**Consultation Response from KC, Highways Development Management**
**2021/93399 Land Adjacent to, 569 , New Hey Road, Mount, Huddersfield, HD3 3XN**
**Outline application for demolition of agricultural and storage buildings and erection of residential development (& dwellings)**
**Date Responded: 01/10/21**
**Responding Officer: J Turner**
**Responding Ref: K2-6SE/21**

This application seeks outline approval for the demolition of agricultural and storage buildings and the erection of a residential development at New Hey Road, Mount. Only access and layout are being considered at this time, with all other matters reserved.

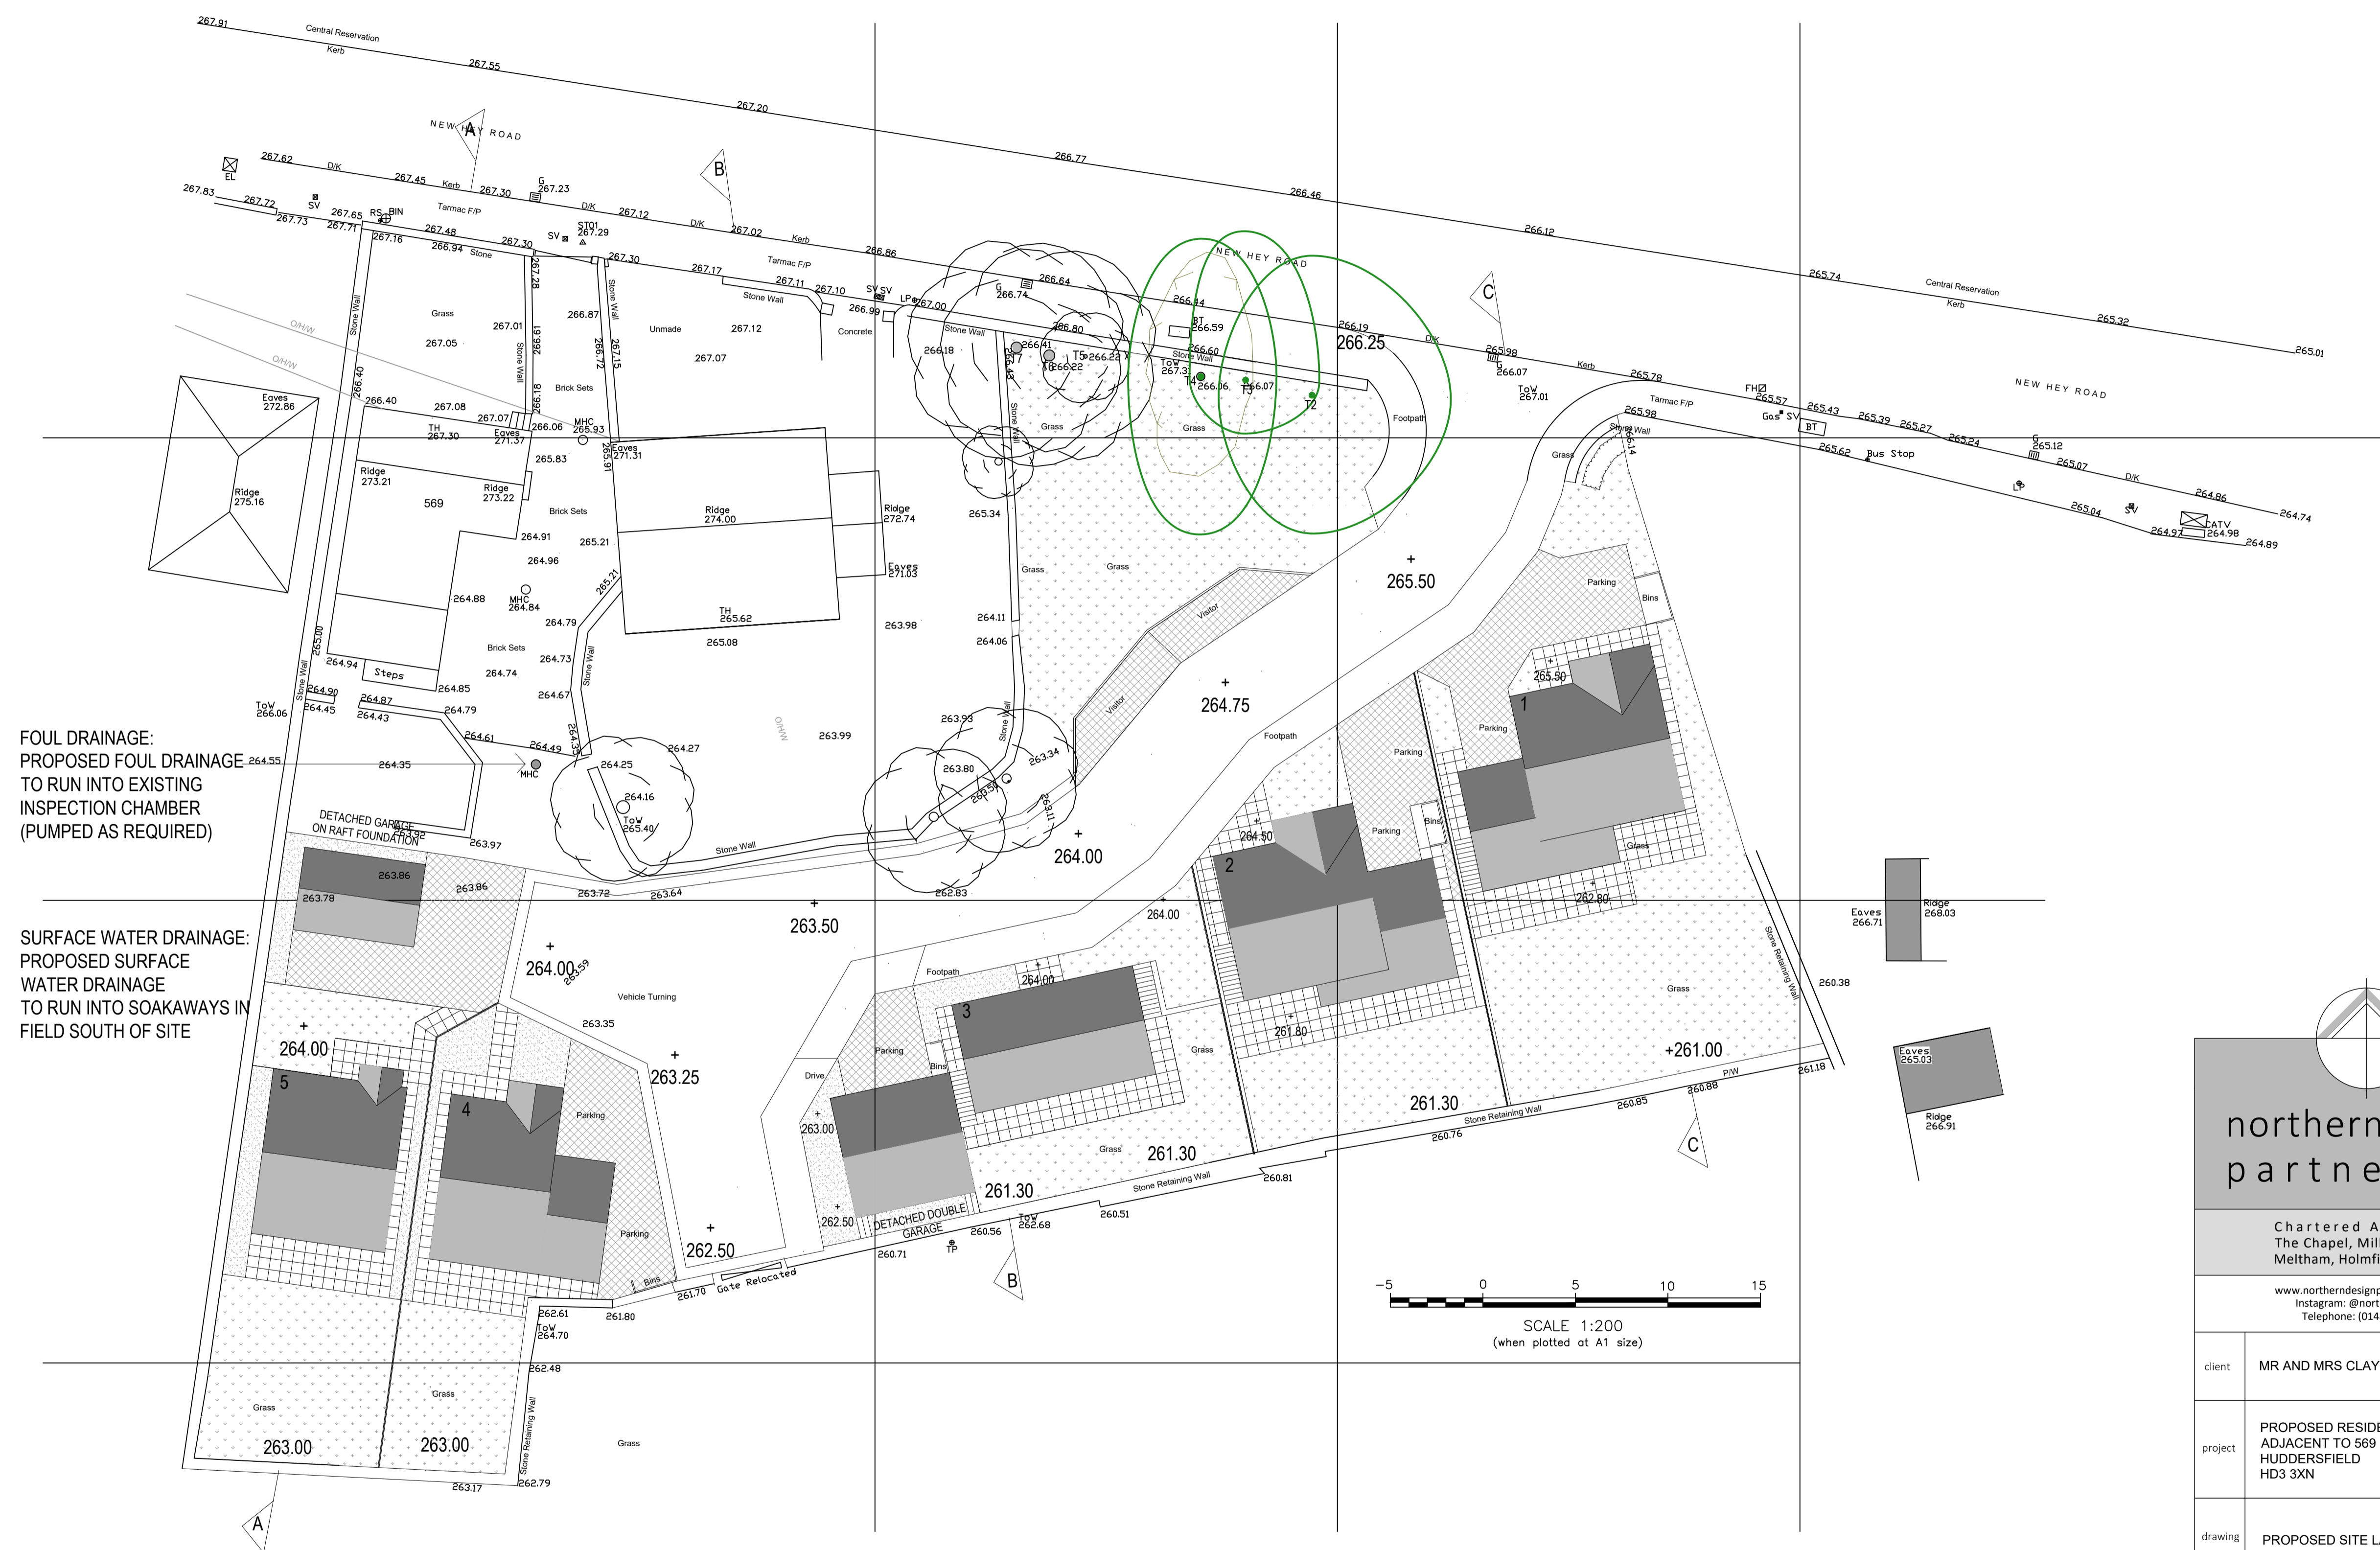
The layout plan submitted by the applicant shows seven dwellings being served from a new access off New Hey Road. Given the number of dwellings, the road should be made up to adoptable standard and offered for adoption via a Section 38 agreement.

The Section 38 department have raised concerns regarding the gradients of the carriageway and footway within the site. As per the advice in Kirklees Highway Design Guide SPD, the following comments were made:

“The general rule is that shared spaces should have a gradient not steeper than 1:20.

Share spaces with a maximum longitudinal slopes of 1:10, separate off-carriageway facilities for pedestrians must be provided.

This footway shall be to an independent vertical alignment to the adjacent carriageway to reduce the maximum gradient required. Level ‘landings’ at spacing appropriate to the gradient and handrails shall be provided for pedestrians. Consideration shall be given to the provision of parallel, alternative routes utilising steps to reduce local gradients.

Given drawing no. 2120-01 a footpath is allowed for, but as the footway is parallel to the carriageway. Given this, a 1:13 maximum gradient with intermediate landing distances should be the tolerances to undertake the vertical design for the proposed road.”

Additionally, swept-path analysis should be provided for an 11.85m refuse vehicle entering and exiting the site in a forward gear.

Off-street parking should be provided in line with the advice set out in the Highway Design Guide SPD. Although resident parking cannot yet be calculated at this outline stage, two off-street visitor spaces should be provided for the seven dwellings.

The sightlines at the junction with New Hey Road should be demonstrated to achieve 2.4m x Y distance (Y distance be of the 85th-percentile wet weather speed on each approach to the junction) from the results of an up-to-date independent speed survey.

Even at this outline stage, amendments to the layout will be required as per the above advice.
